**Consultation Response from KC,
Highways Development Management****2023/91768 land off, Netherley Drive, Marsden, Huddersfield, HD7 6HL****Erection of 2 dwellings****Date Responded: 18/01/2024.****Responding Officer: D. Stainsby****Responding Ref: K1-7/4****RECOMMENDATION:**

As submitted the proposals are not acceptable to Highways.

Existing Site Plan
scale @ A1. 1:500

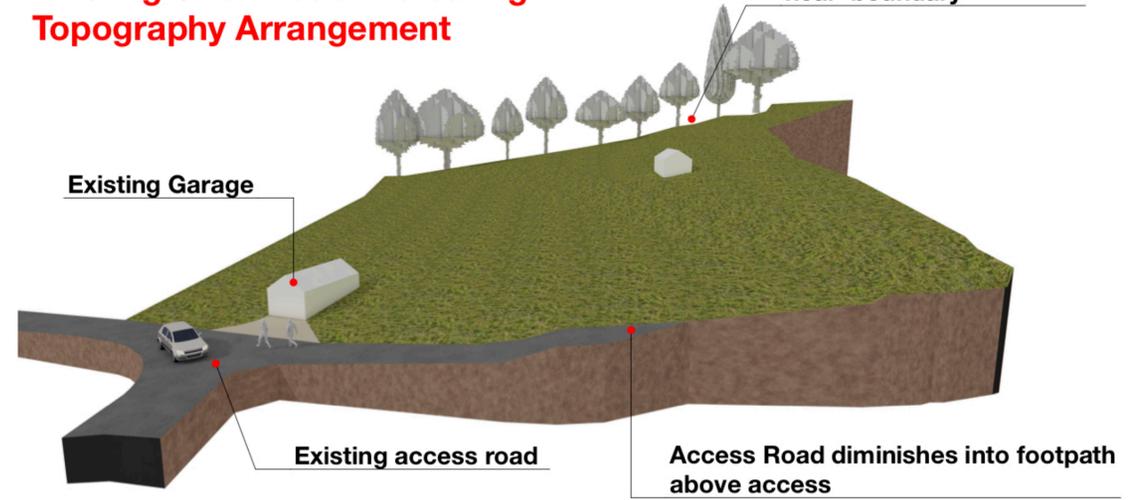
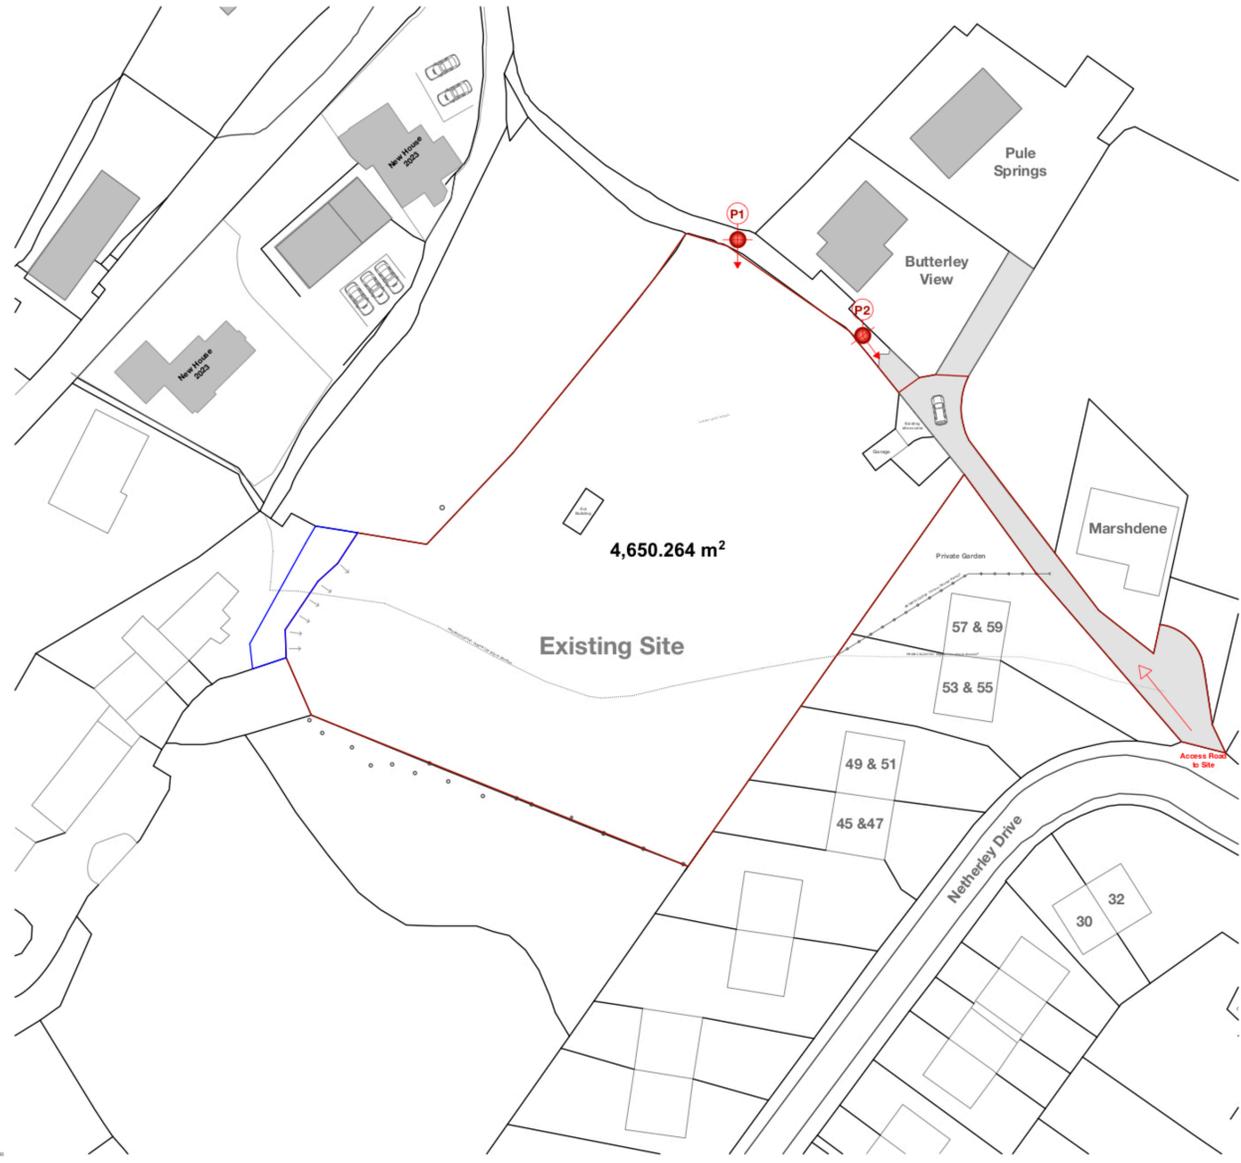
Access is proposed off Netherley Drive via private driveway which currently serves four existing dwellings.

This proposal would increase the number of dwellings being served by the private drive to six.

There is an existing Public Right of Way (PROW no 207) running along its length and connects to Old Mount Road.

No acknowledgement of the existing PROW has been submitted.

The current access track is of unsuitable standard and width to accommodate this development.

In line with the Councils Supplementary Planning Document (SPD) – Highway Design Guide, roads serving more than 5 dwellings should be adopted by the Council and therefore built to adoptable standards. The current submission does not accord to this standard and is considered unsuitable in its current form.
